**KIRKLEES METROPOLITAN COUNCIL
INVESTMENT & REGENERATION SERVICE**

DELEGATED DECISION TO DETERMINE PLANNING APPLICATIONS

Reference No:	2025/62/93487/W
Site Address:	2, Belton Grove, Birchenclyffe, Huddersfield, HD3 3RF
Description:	Erection of two storey and single storey side extensions with rear dormer and associated alterations
Recommending Officer:	Joshua Merriman

Officer Report – 2025/93487

Front Elevation 1.100

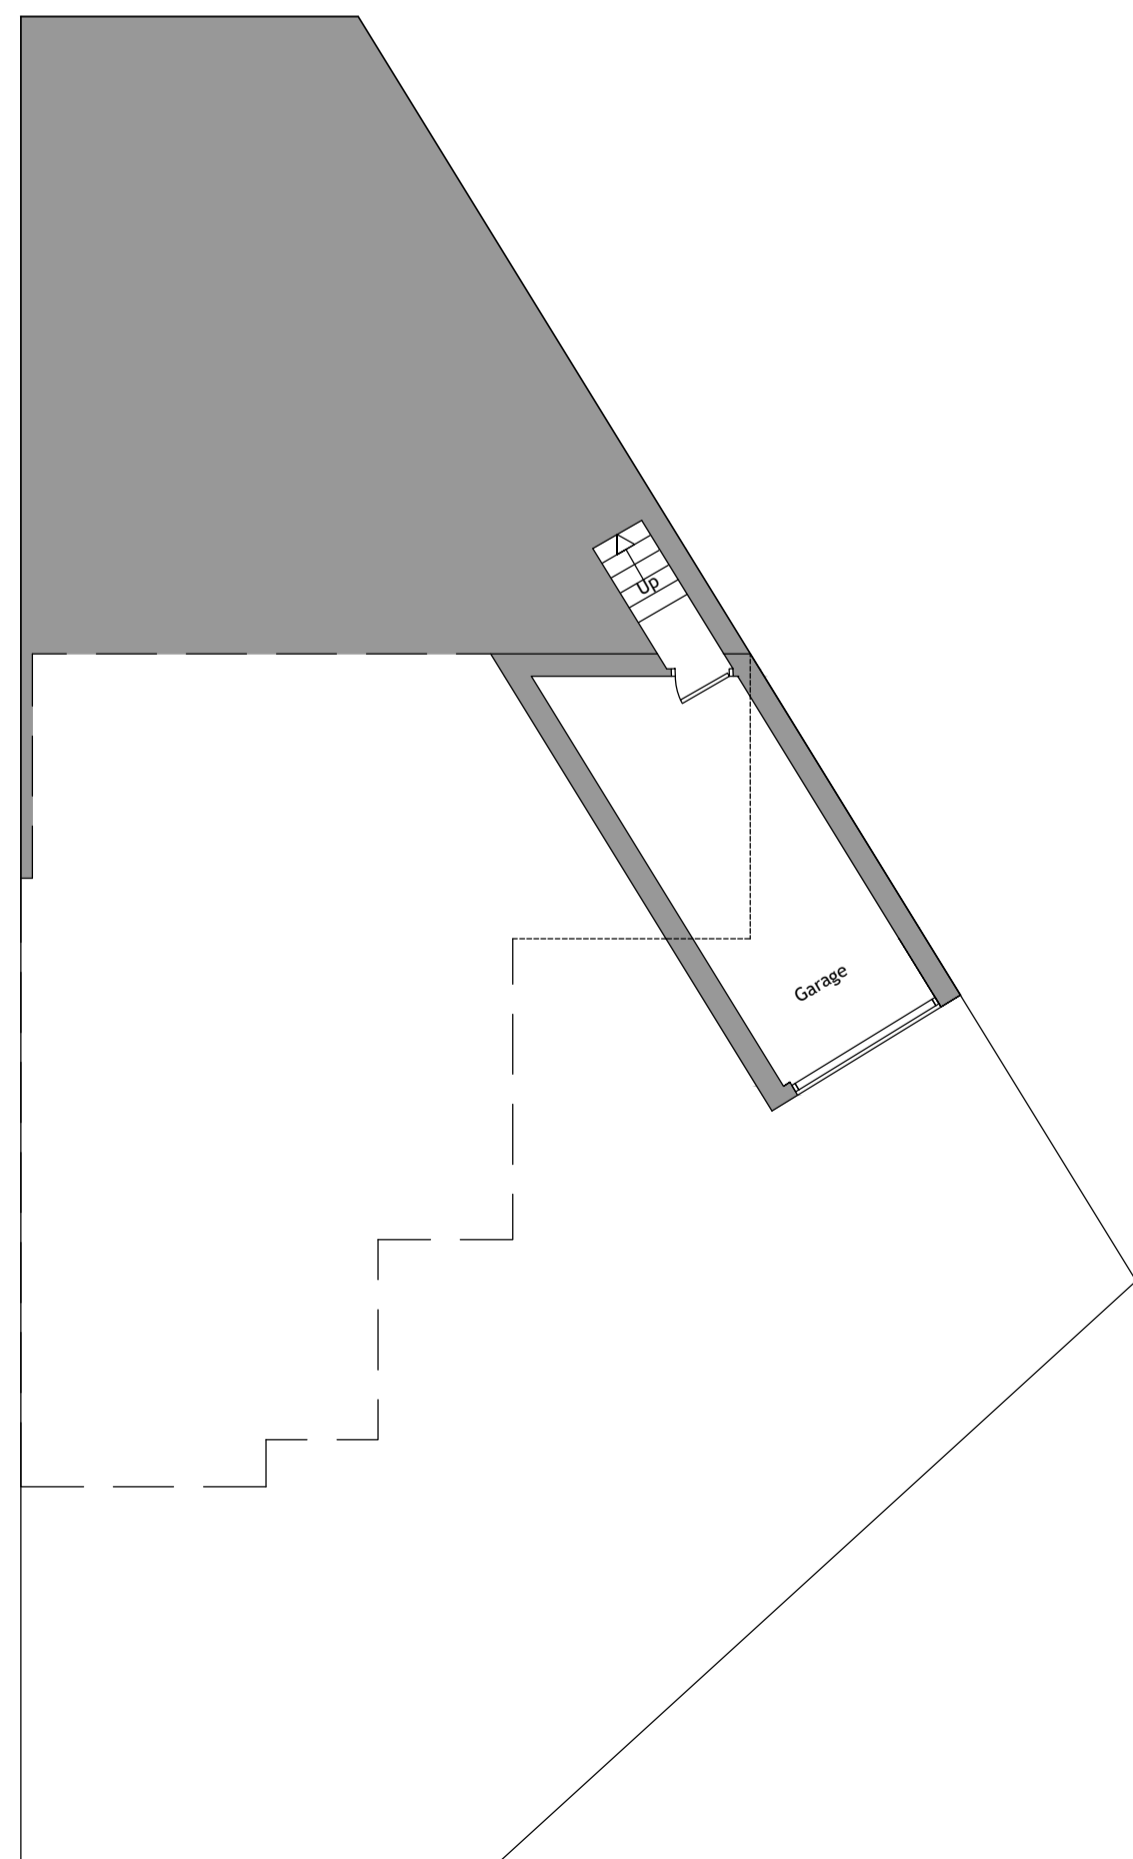
The amendments included reducing the width of the dormer to that of the original property, reducing overall height of dormer; squaring off the single storey side extension to increase visual appeal, an extended roof slope to the front elevation of the two storey side extension, removal of the window to the front elevation of the two storey side extension, windows changed to match those in the existing building.

The proposed single storey side extension does not extend further than two thirds of the width of the original house and is constructed using matching materials.

The two-storey side extension is compliant with the relevant policies for two-storey side extensions as set out in the House Extensions and Alterations SPD, and as a result of the extension in roof slope and removal of front window is considered to be visually sympathetic to the host property and street scene.

Finally, the proposed rear dormer has been reduced in scale to no longer dominate the rear roof plane and is set below the ridgeline of the existing roof, appearing proportionate to the existing dwelling.
